Sydney Olympic Park New High School

Architectural Response to SDRP Report

Authority: State Design Review Panel

GATHER SPACES NUMBERS

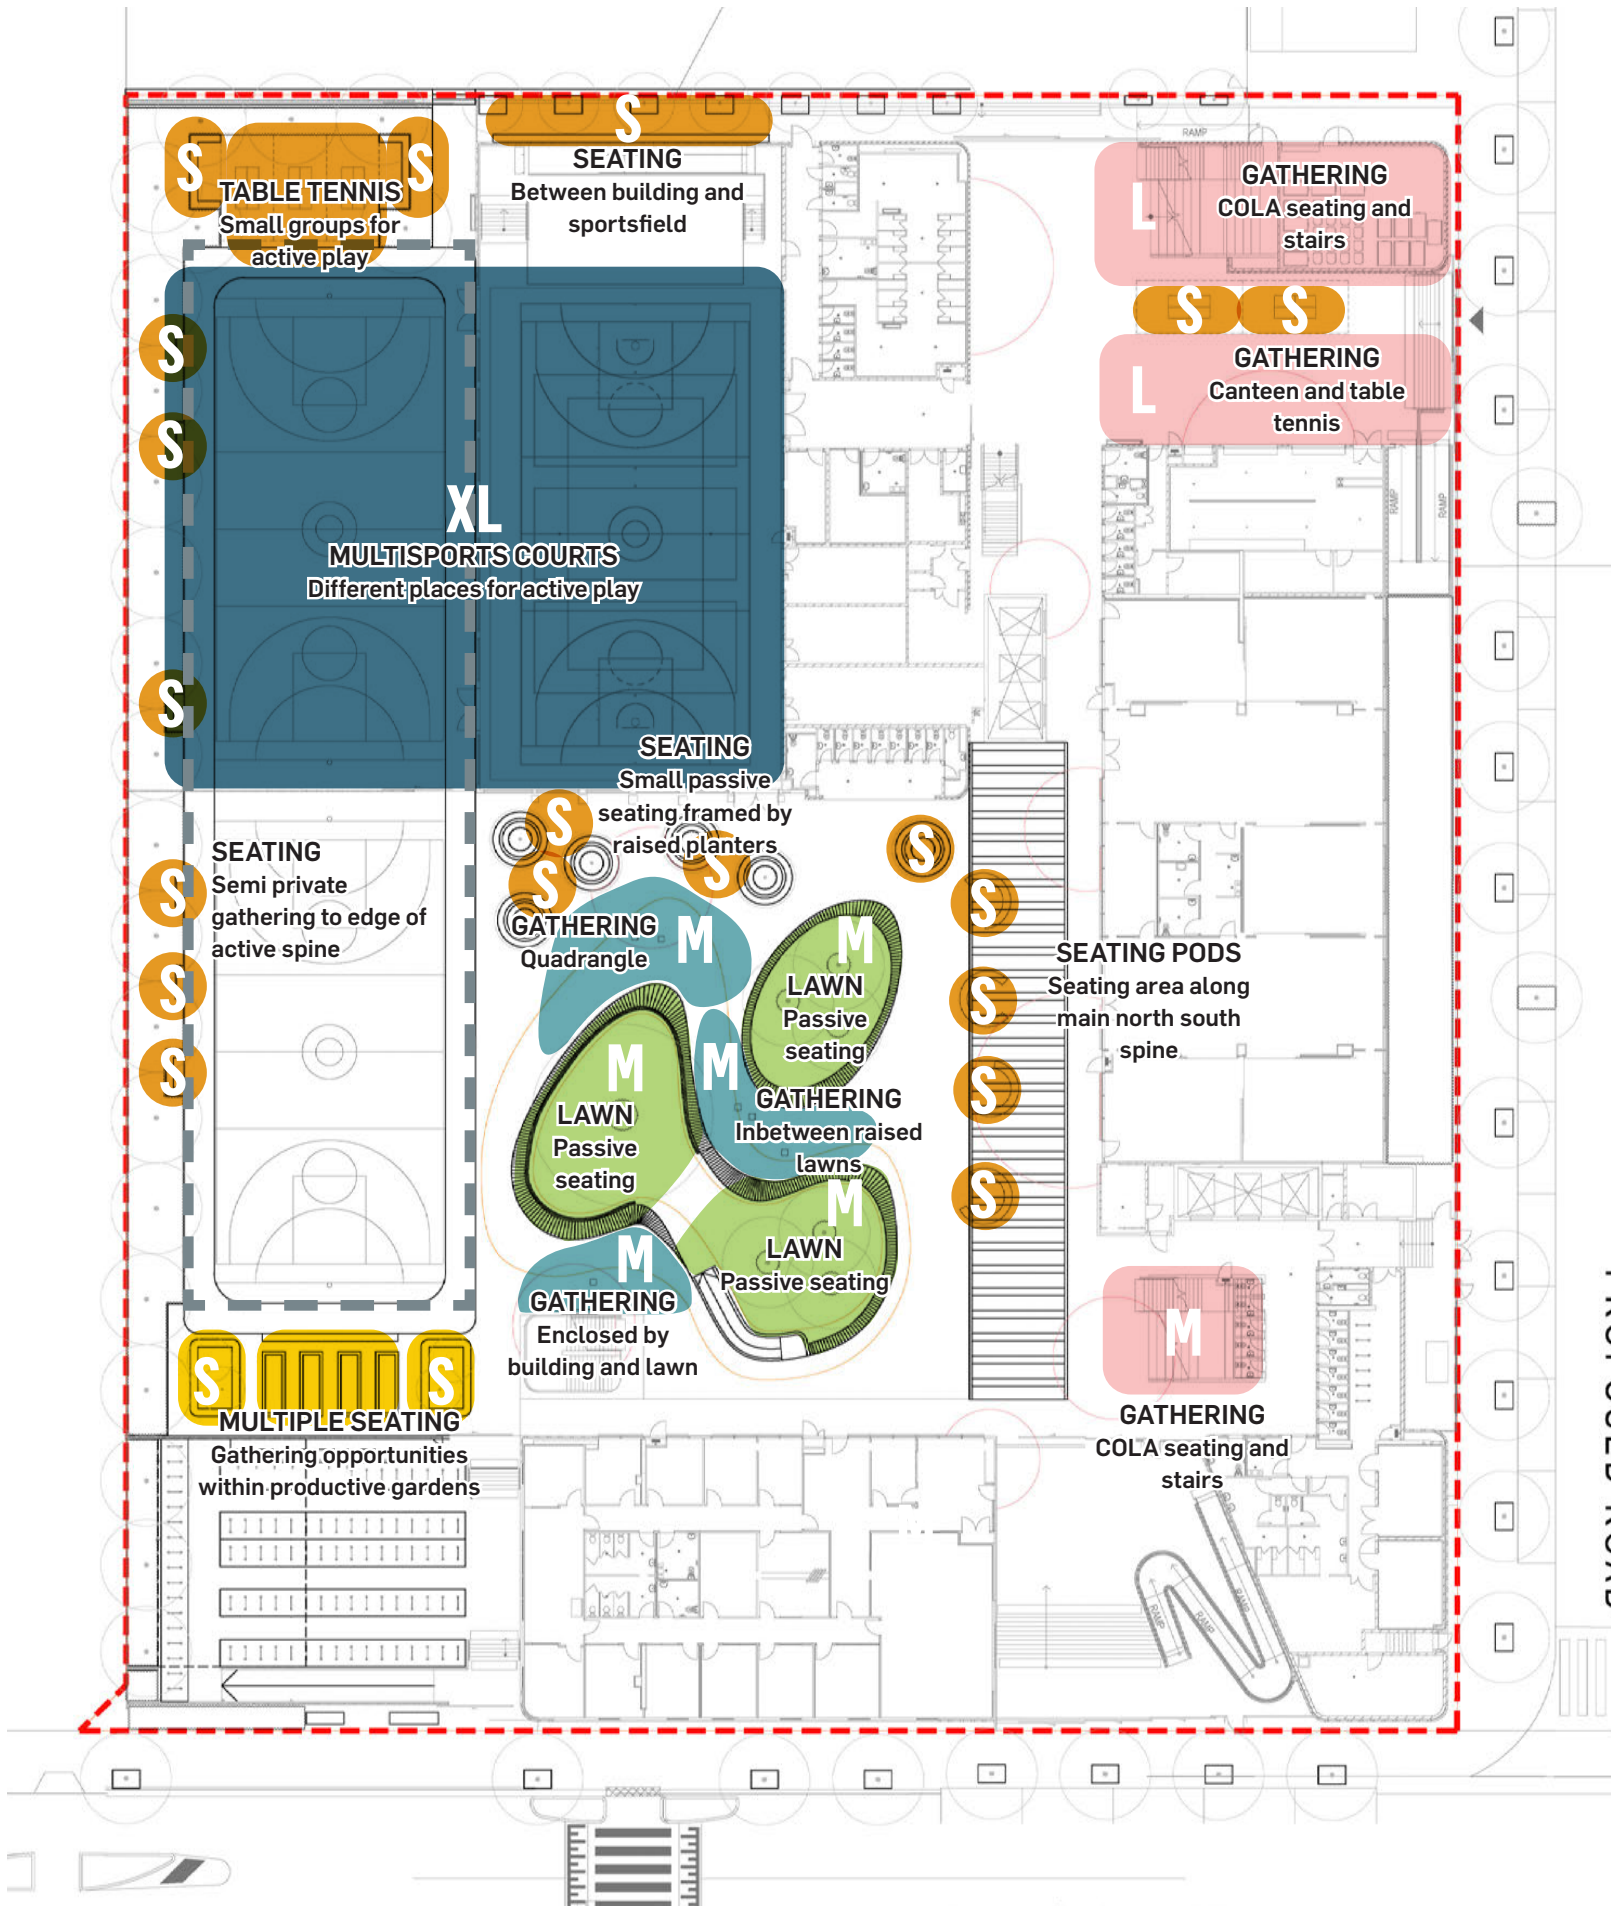
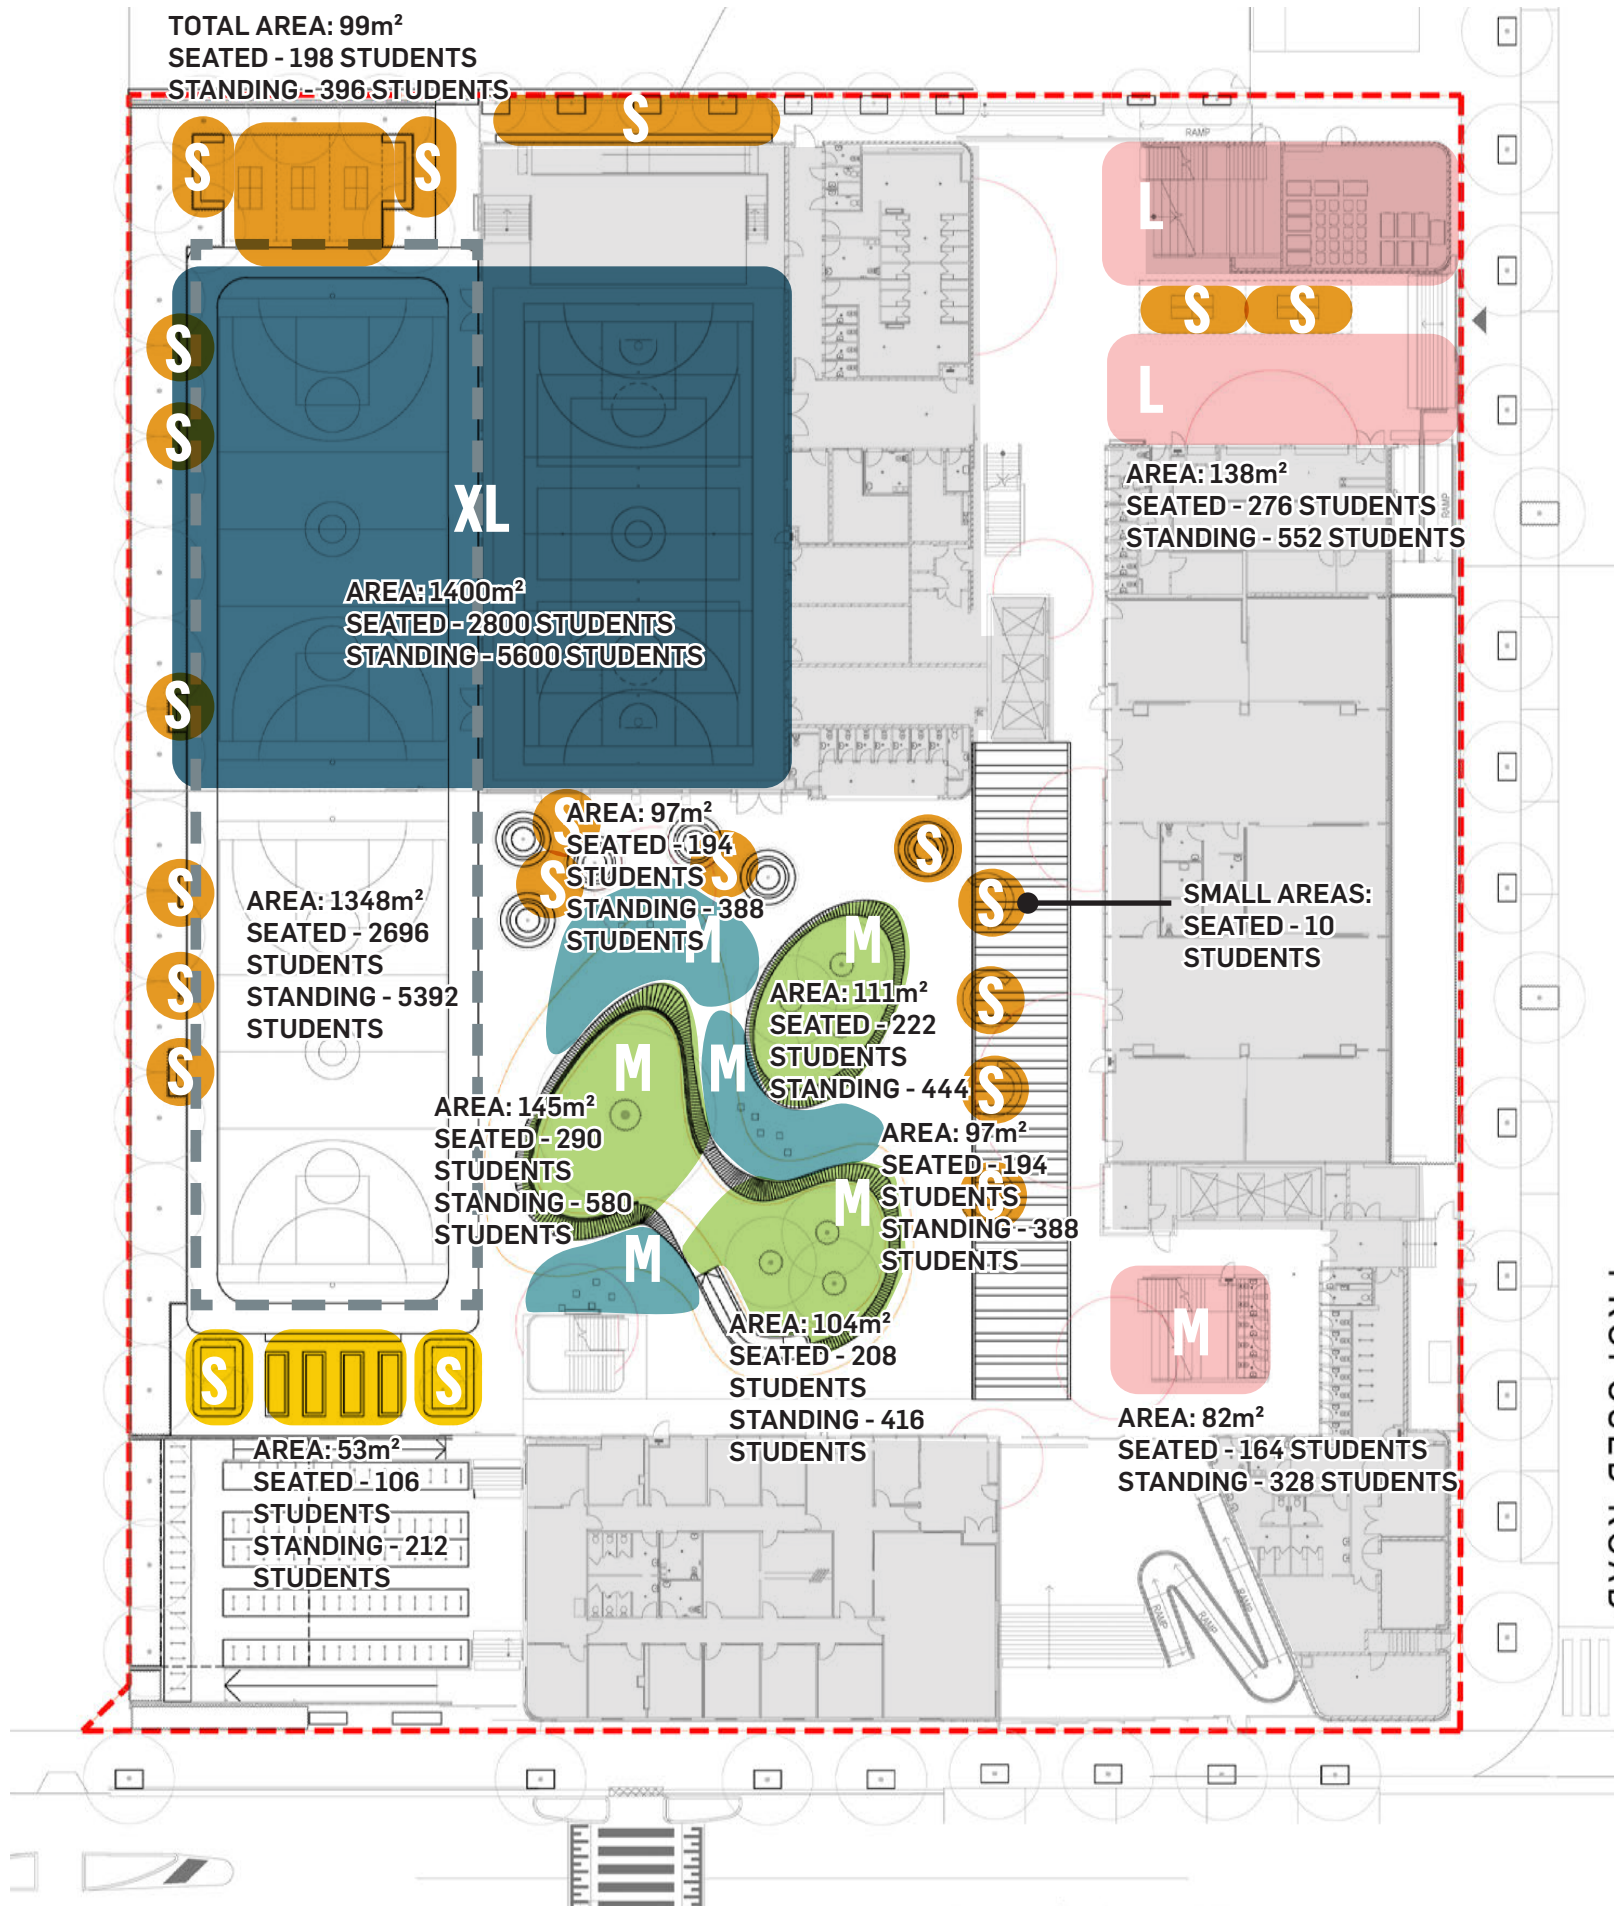
Comment: Gathering spaces – Illustrate the modes of use and number of people that can be accommodated in the various gathering spaces and open areas, particularly in the central courtyard.

Urbis have added a Gathering Spaces Use and Number of People diagram to illustrate the capacity of the small, medium, large and extra-large spaces.

INDICATIVE FENCING

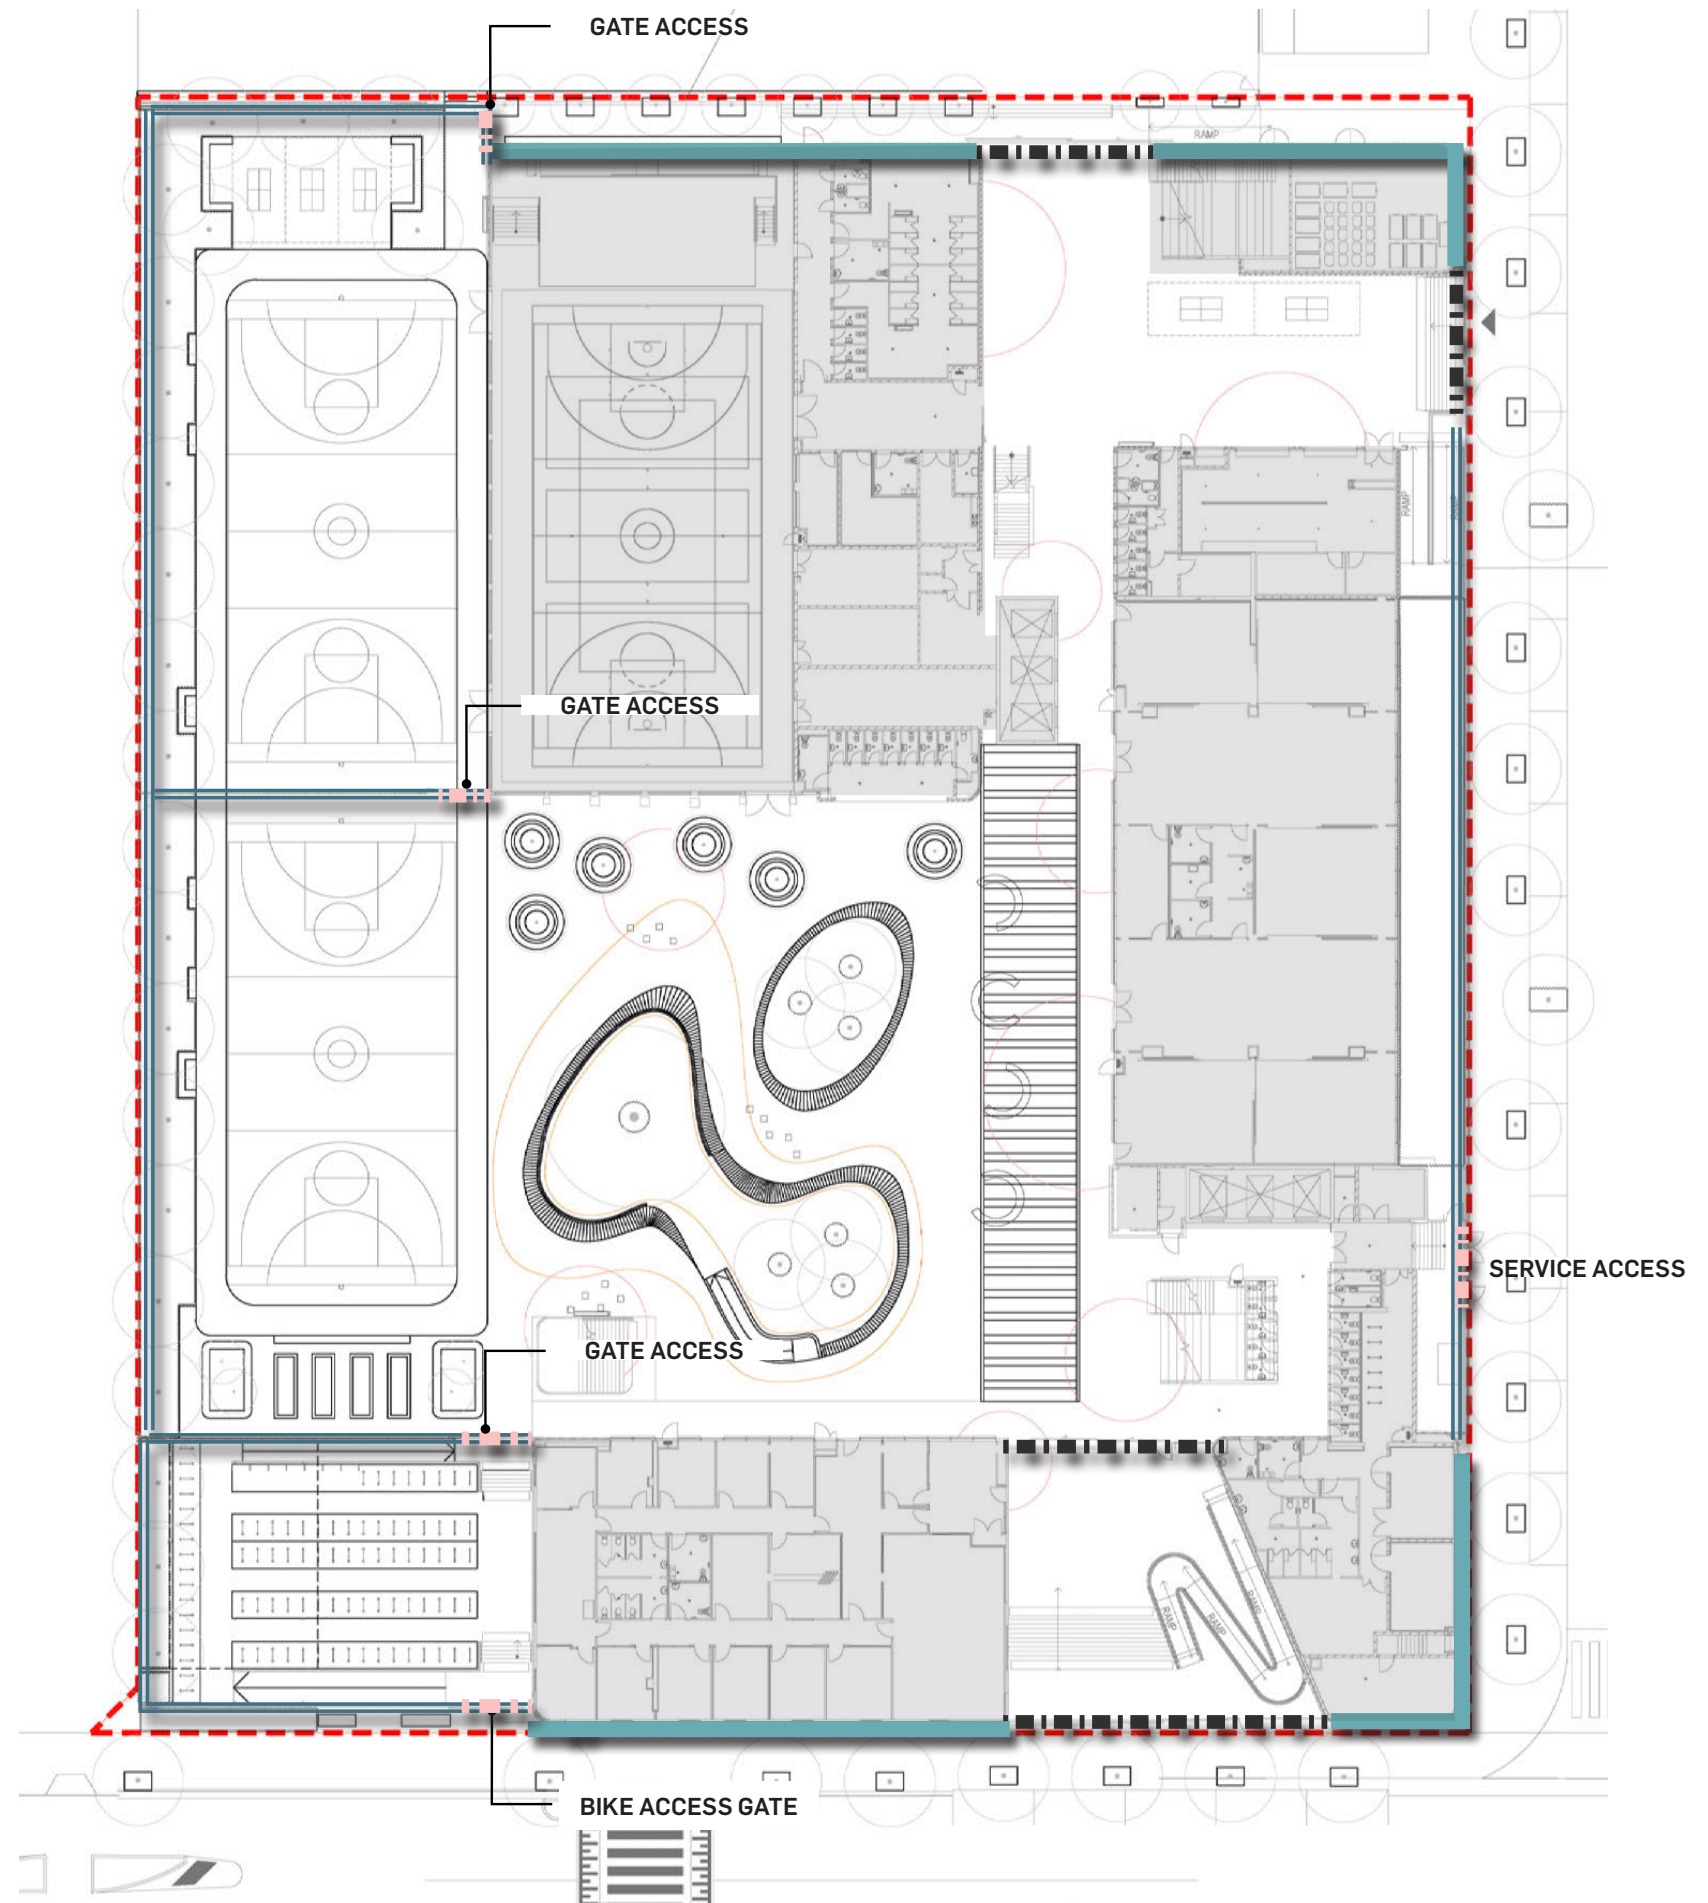
Comment: Building as boundary – The fences along the boundary of Eastern Road appear unwelcoming and are an inappropriate urban response. Undertake further design development to enable the building to define the urban edge. Provide a diagram clearly indicating the extent, height and character of all proposed fencing lines.

Comment: Sports field – Resolve the interface between the school grounds and the sports field to the north. Indicate the location, size and extent of fences and gates and opportunities for connectivity. Consider extending the perimeter planting along the northern setback of the hall.

The interface between the school and future sports field has been further developed in order to minimise the length of fencing required, allowing the building to mark the secure line where possible.

The design progression explained in the series of diagrams, show current resolution for the northern interface. The design response is to allow the northern walls of the gym and waste store to act as the school's secure line. Also noting the SDRP's suggestion, planting has been extended along this boundary, where appropriate.
